From: Lorimer, Elliott <Elliott.Lorimer@lancashire.gov.uk>
Sent: 20 January 2015 14:21
To: planning
Subject: RE: Consultation on planning application 3/2014/1109 land west of Trough Road and south of Langden Drive, Dunsop Bridge

Please find below my comments regarding the planning application 3/2014/1109 on behalf of the AONB Partnership. These comments have also been sent to the Planning Inspectorate's Common Land team who are also consulting on the proposed WWII memorial stone, due to the fact the site is also common land:

PROPOSED ELEVATIONS

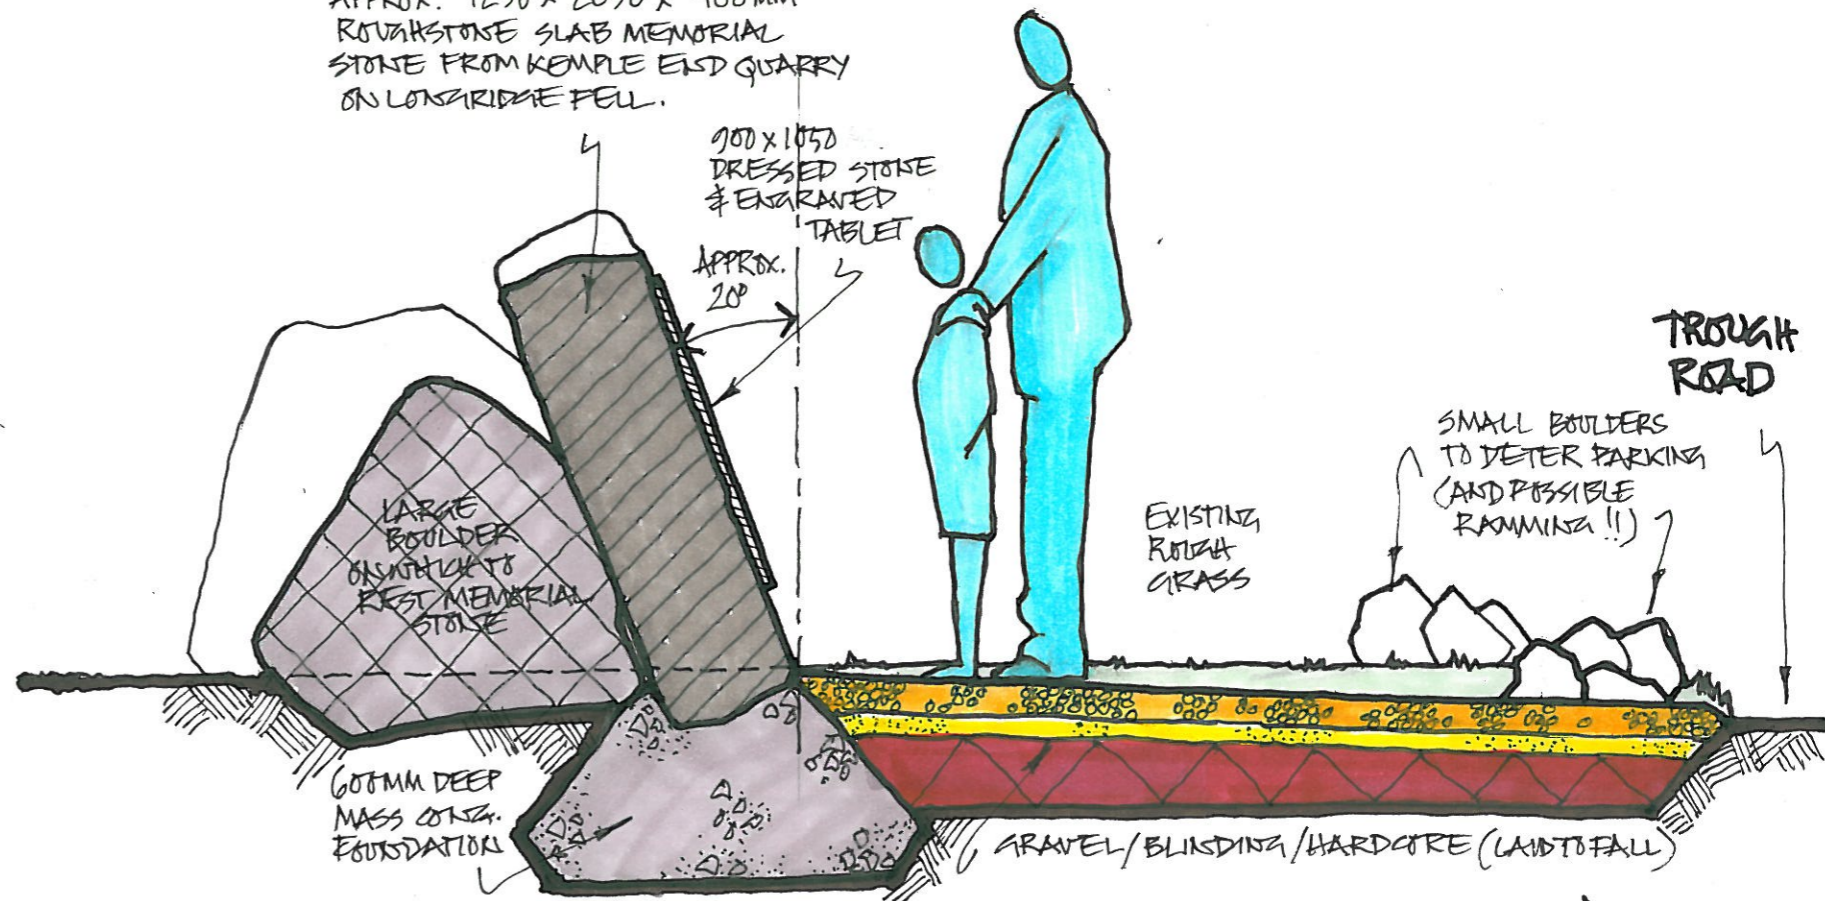
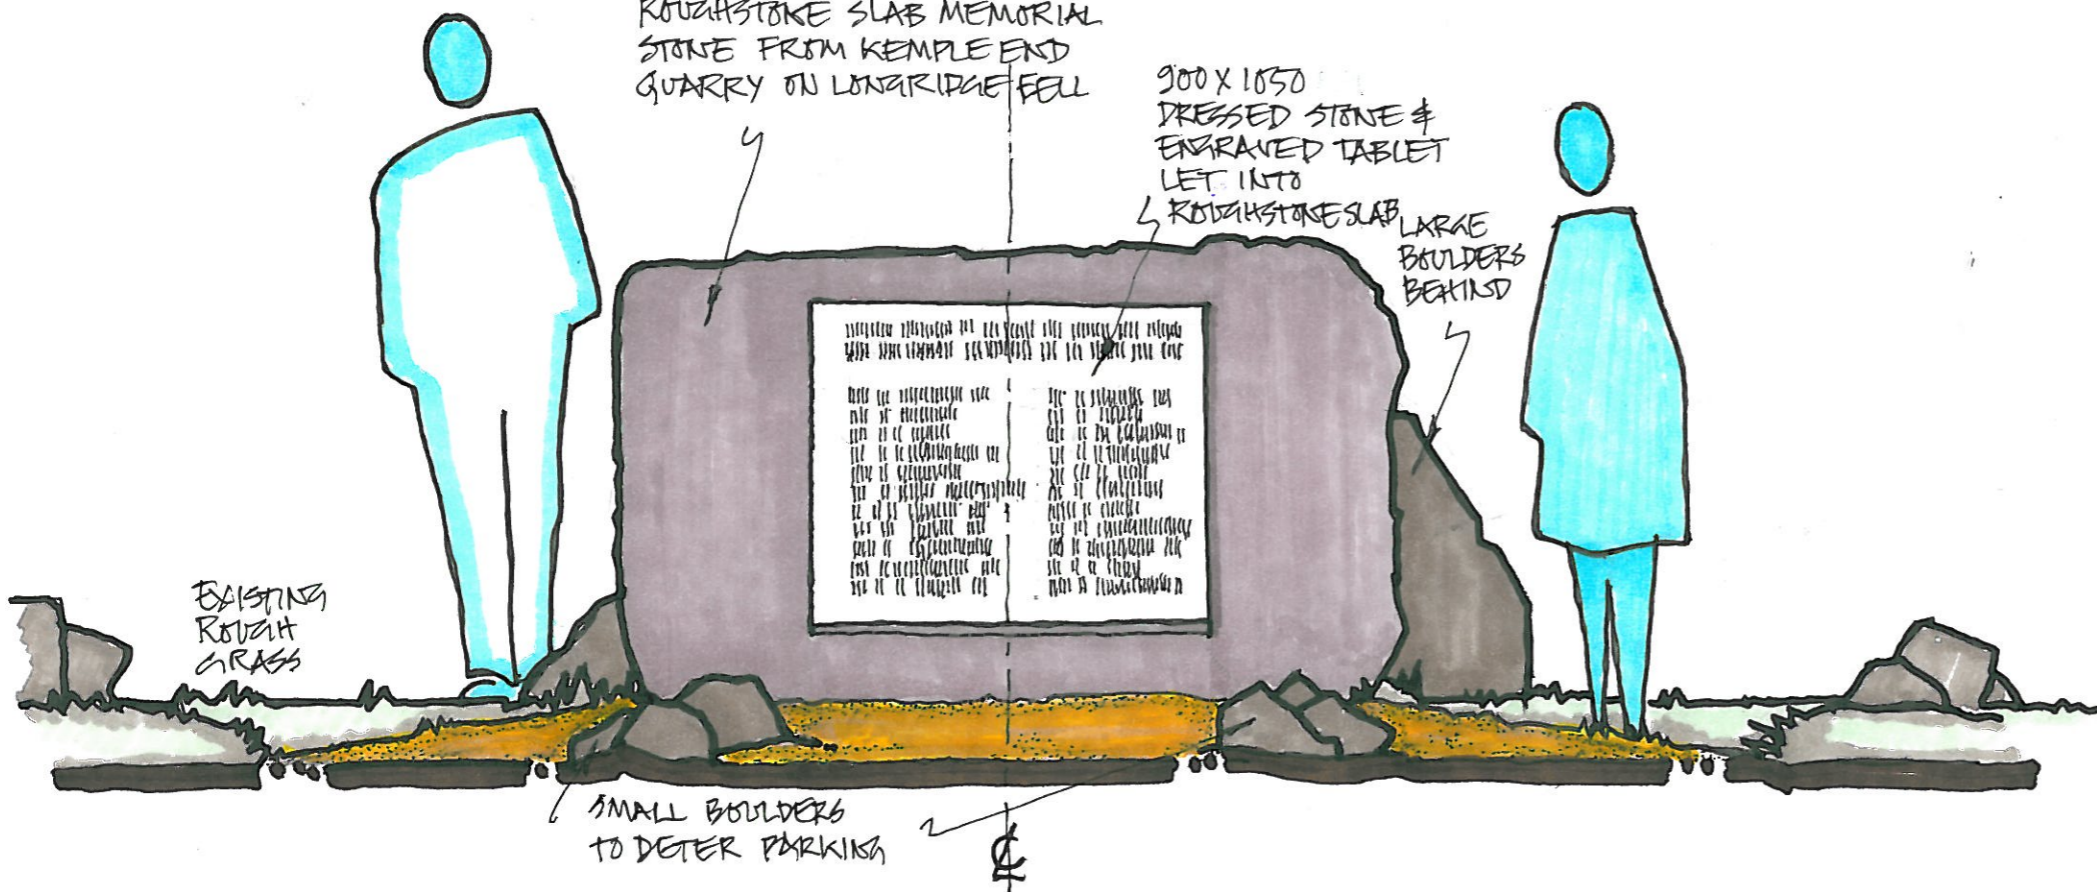
1. The proposed memorial stone is quite large (1.25m x 2.05m approx.) and may appear quite conspicuous at what is a fairly informal lay-by/car park. Could the applicant consider a smaller memorial stone, which would still be able to accommodate the stone tablet?
2. The proposals for the WWII memorial include a relatively formalised gravel area (5m² approx?) with stones along its boundary. Again, this would be a change to the existing informal lay-by/car park area and may again appear conspicuous within the relatively undeveloped countryside at Sykes Green Common. Accepting that there may be a need to stabilise/strengthen an area in front of the memorial to reduce erosion/wear from visitors looking at the memorial, would the applicant consider reducing the size of this gravelled area to small area just in front of the memorial stone?
